**WARKWORTH CONTINUATION PROJECT (SSD 6464)  
RESPONSE TO SUBMISSIONS REPORT**

Reference is made to your email to the Environment Protection Authority (EPA), dated 11 November 2014, seeking the EPA's comments on the report titled '*Warkworth Continuation 2014 – Response to Submissions Report: November 2014*' (RTS report) prepared by EMGA Mitchell McLennan Pty Limited.

**ATTACHMENT 1****EPA's Air Quality Assessment Comments  
Warkworth Continuation Project (SSD 6464)****24-hour PM<sub>10</sub> Cumulative Assessment****1. Accounting for 2012 Impacts****ISSUE:**

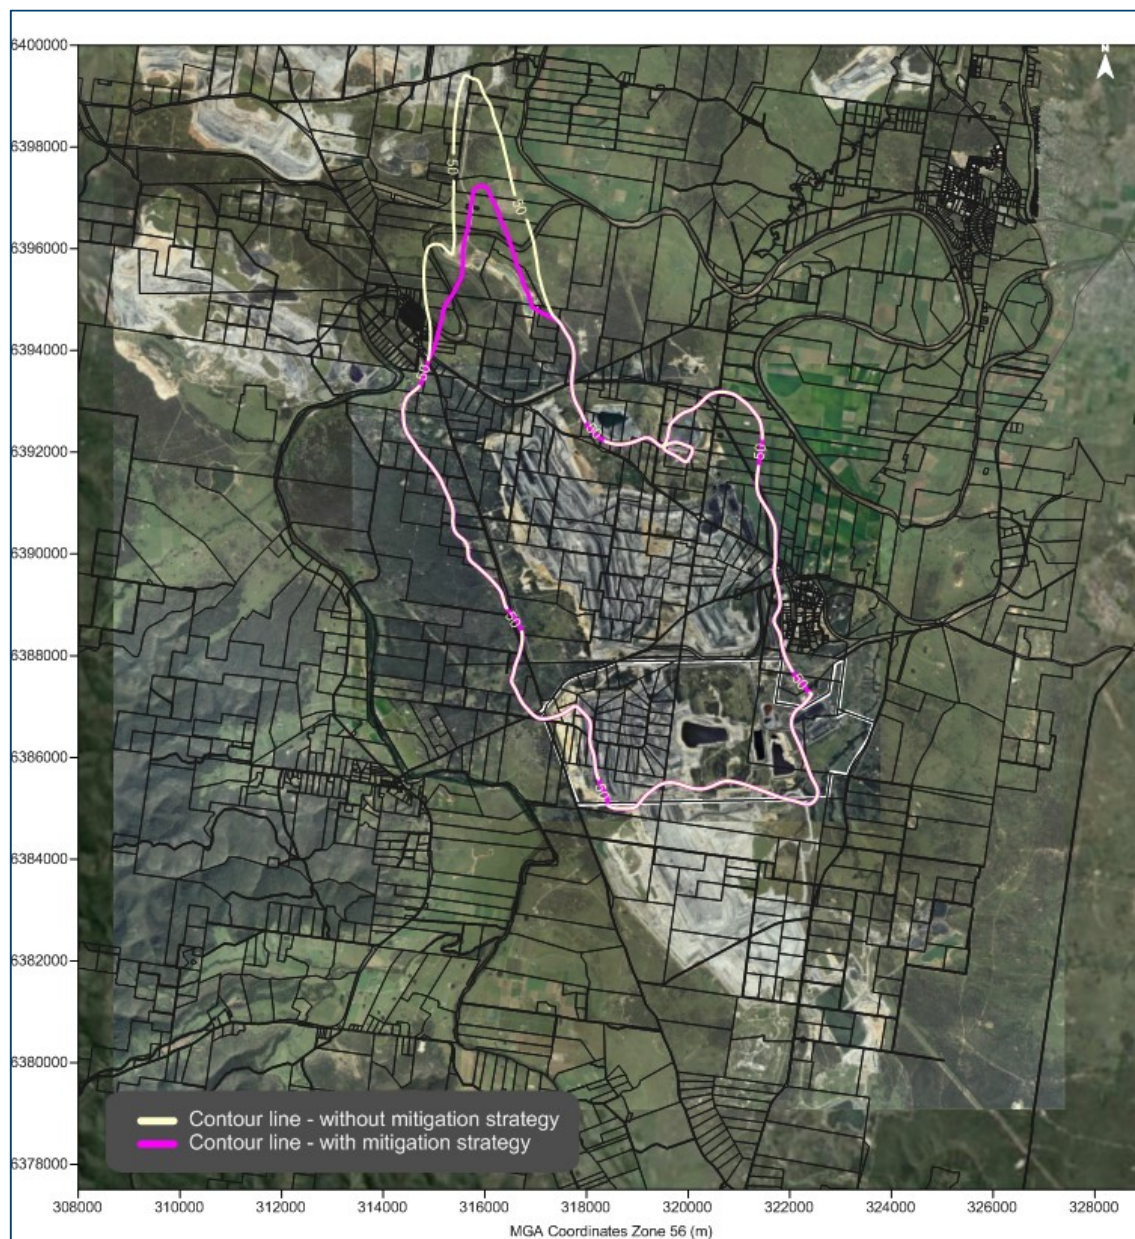
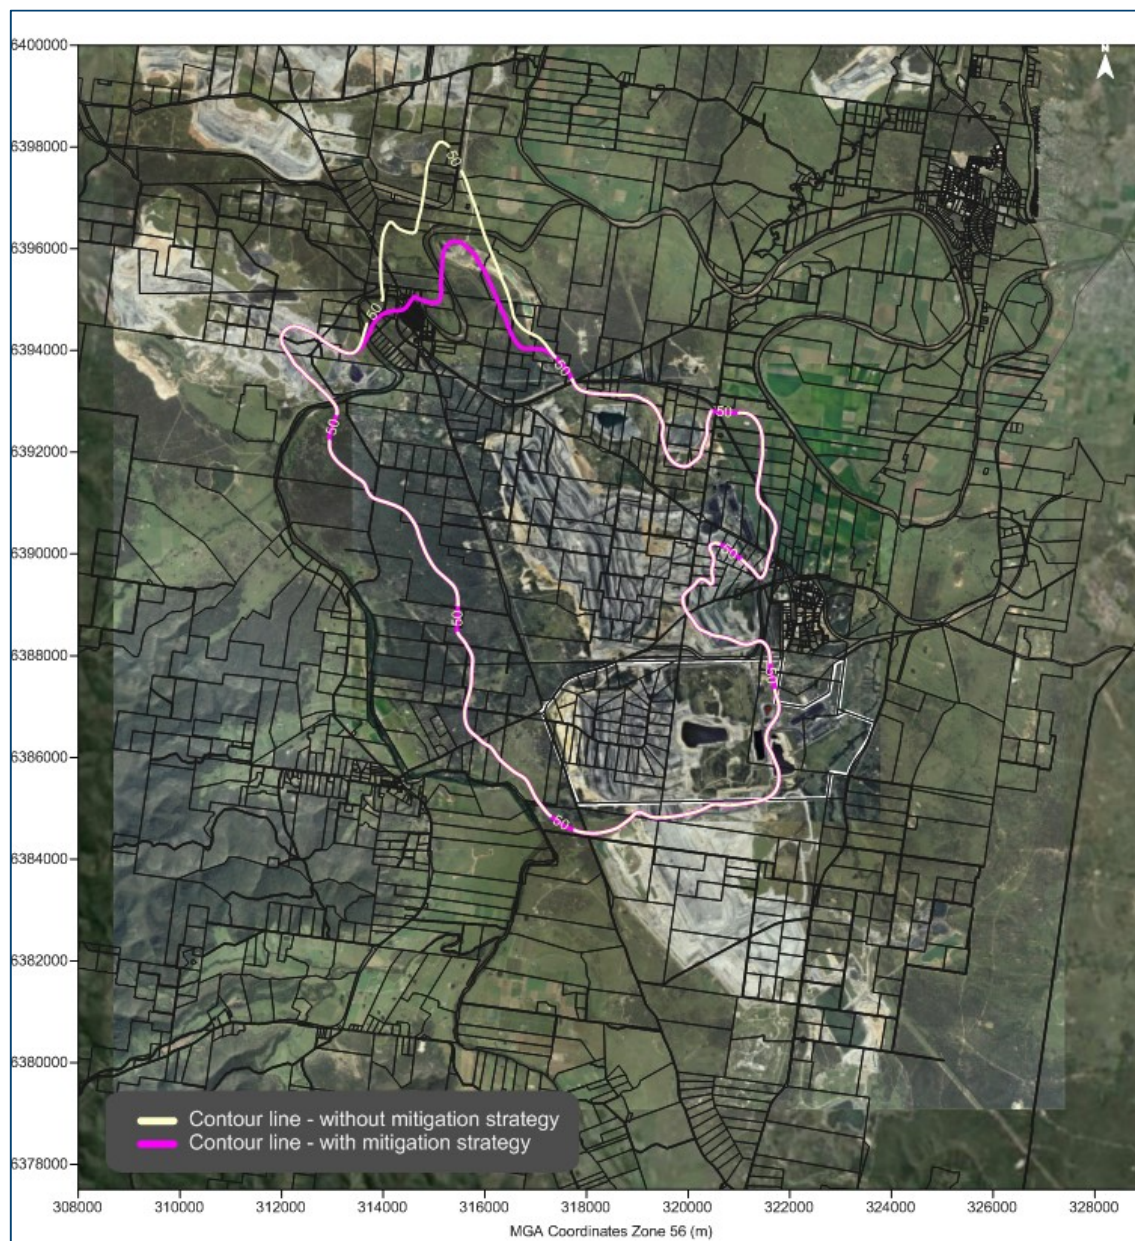
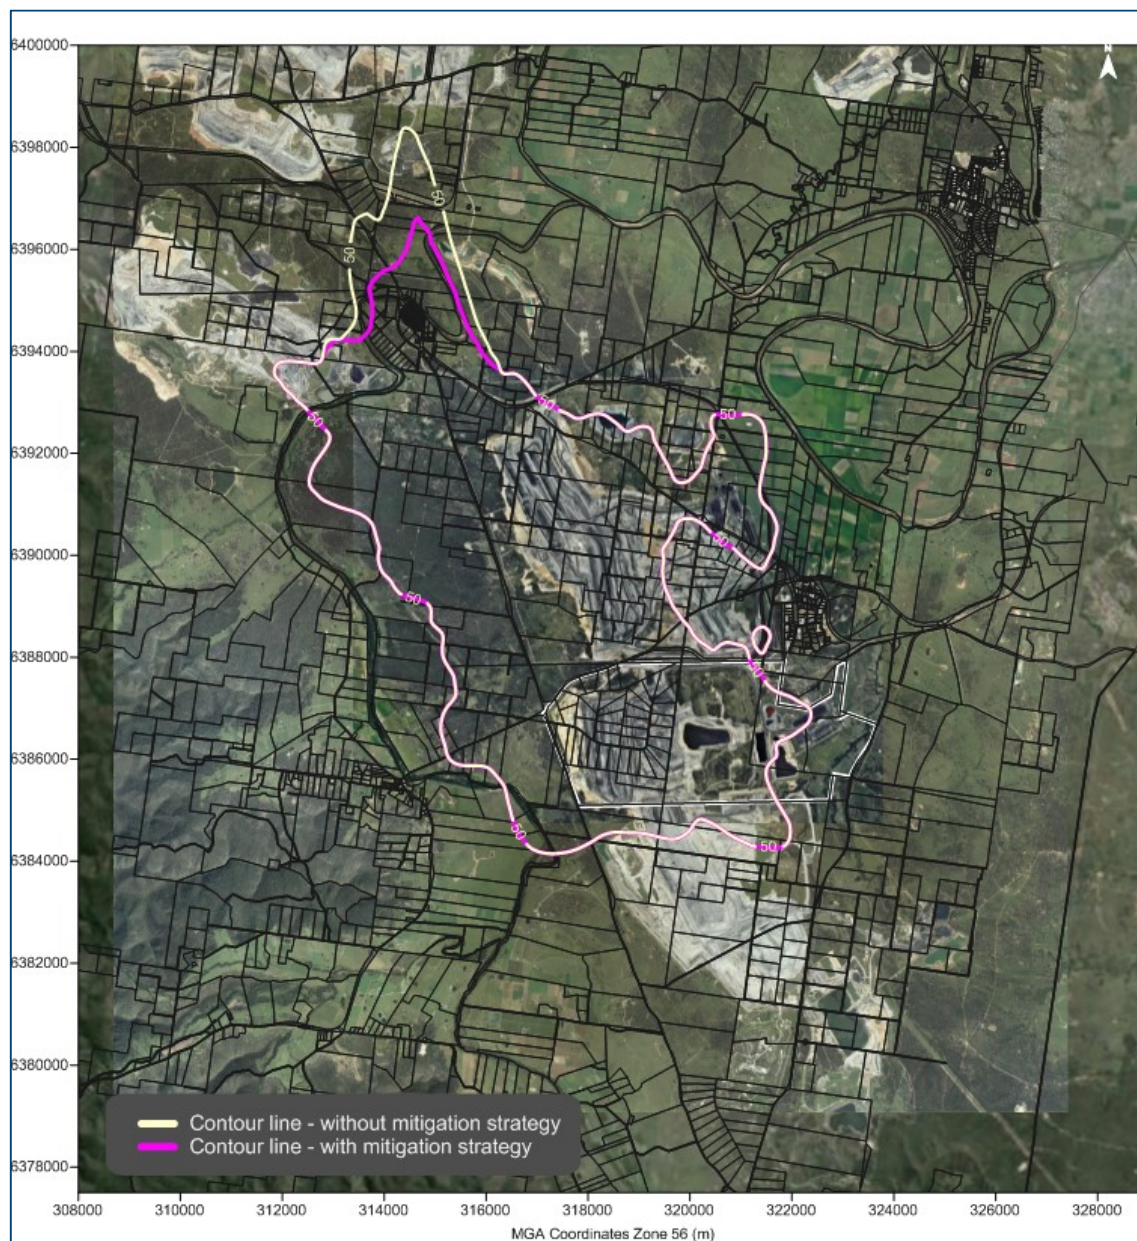
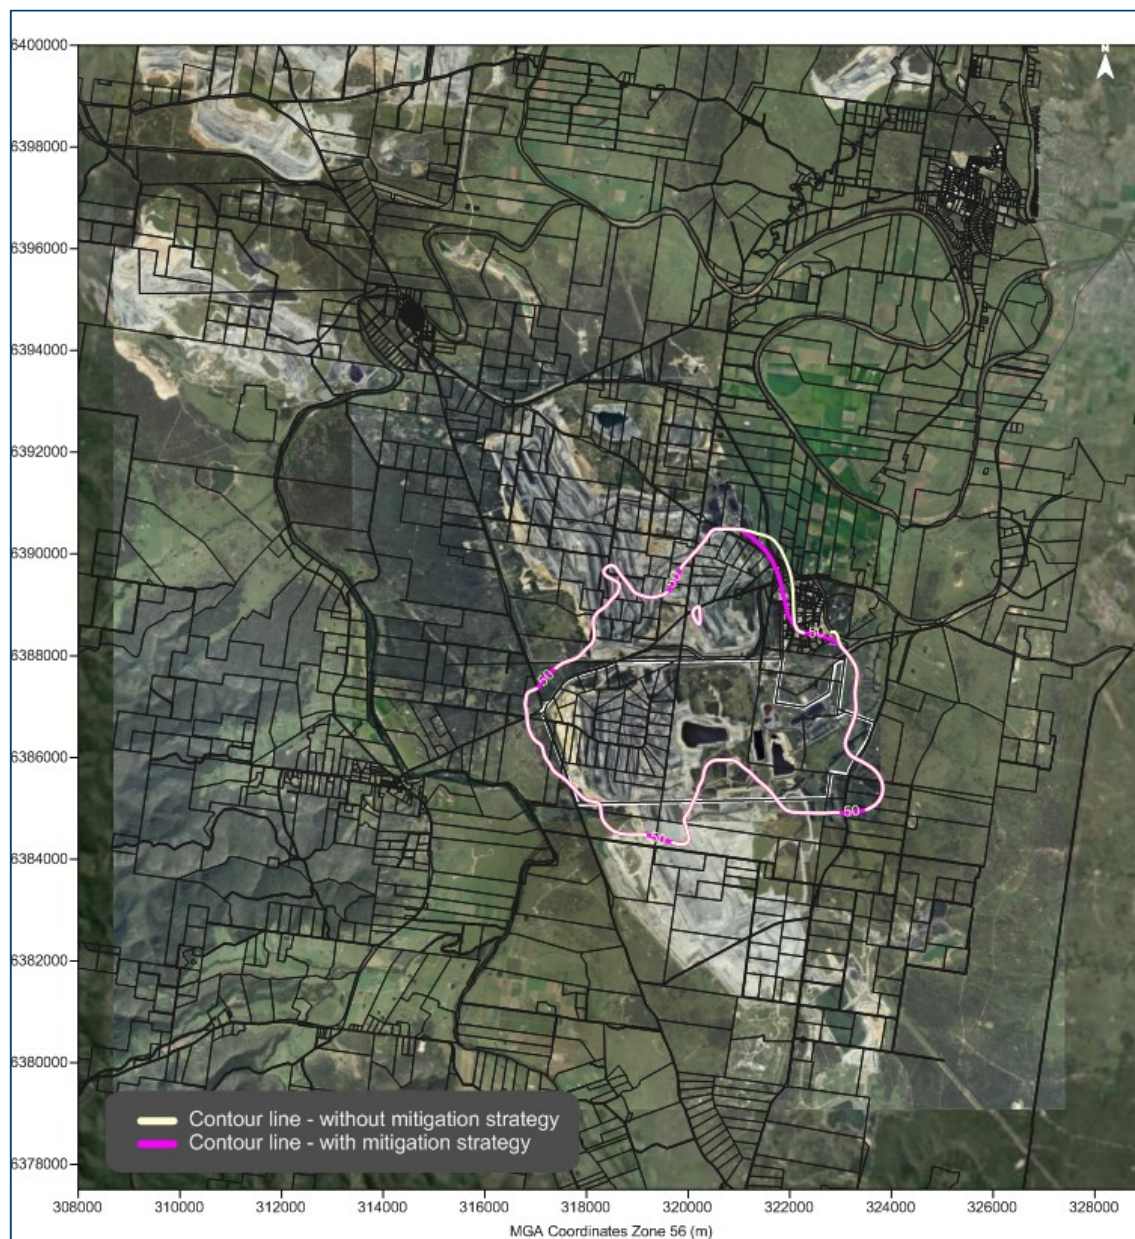
It is noted that the modelled increment (mine contribution) presented is the difference between the modelled future impacts and the modelled 2012 impacts. In other words, the relative change in the future years from base year 2012 has been presented. The actual predicted concentrations for the 2012 base year and the future years have not been provided as part of the assessment.

The presented incremental relative change in concentrations includes contribution from MTO. Whilst it is acknowledged that due to the interactions between the two mines, MTO needs to be considered in the cumulative assessment. However, the Project only contributions should also be provided for transparency in the assessment process.

The proponent should provide the 2012 predicted impacts for everyday of the year for the Project alone and Project with MTO for transparency. Additionally, the proponent should check that the date and background concentration used in the cumulative assessment is consistent.

Figure 1: Measured 24-hour average PM₁₀ concentrations at MTW Bulga TEOM monitor

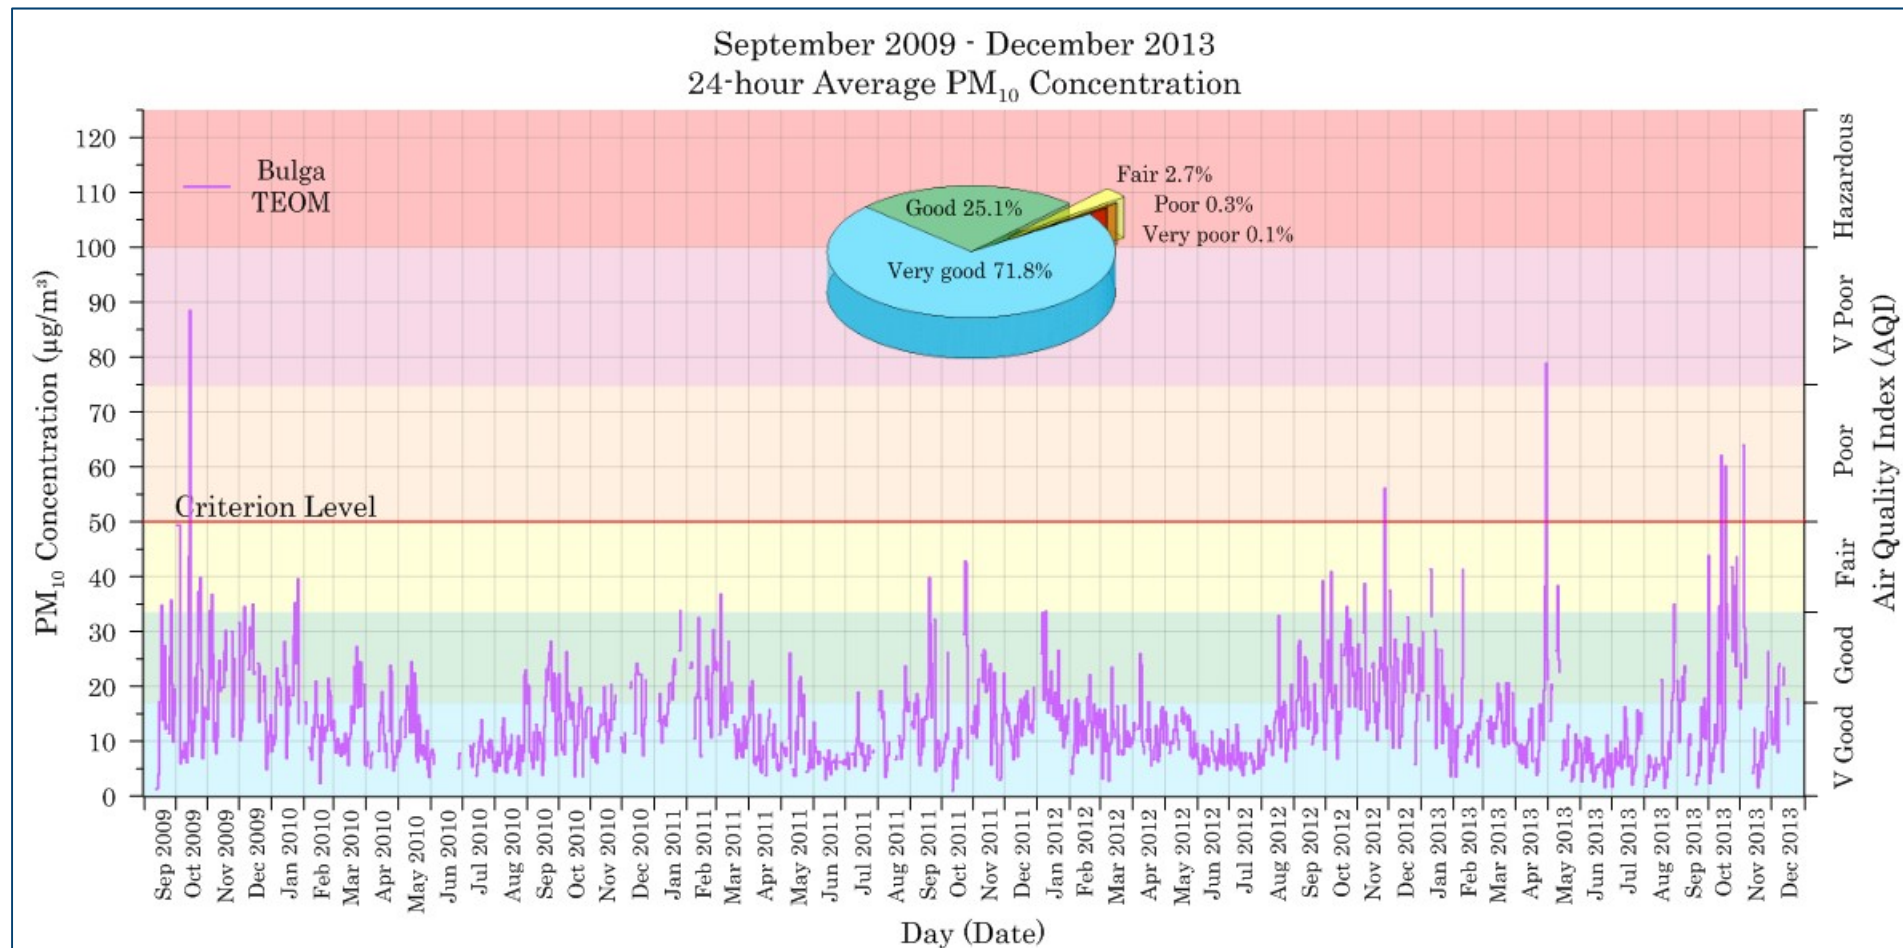
The 2012 emissions inventory was not included as an appendix to the RTS report. The background levels shown in the original Environmental Impact Statement (EIS) and the RTS report appears to be the monitored concentrations at the TEOMs when compared with the monitoring data in Appendix D of the Air Quality Impact Assessment (AQIA). This differs from the background dust level methodology described in the RTS report.

Additionally, it appears there are inconsistencies with the dates of some of the monitored background concentrations in the 24-hour PM<sub>10</sub> cumulative assessment and the tabulated TEOM data in Appendix B of the AQIA. For example, Appendix B of the AQIA does not include the measured concentration at the monitors for 7 October 2012 and the measured concentration on 14 June 2012 at the Bulga TEOM was 12 µg/m<sup>3</sup>. These dates and a number of other dates have different concentrations to the background concentrations presented in the 24-hour PM<sub>10</sub> cumulative assessment tables.
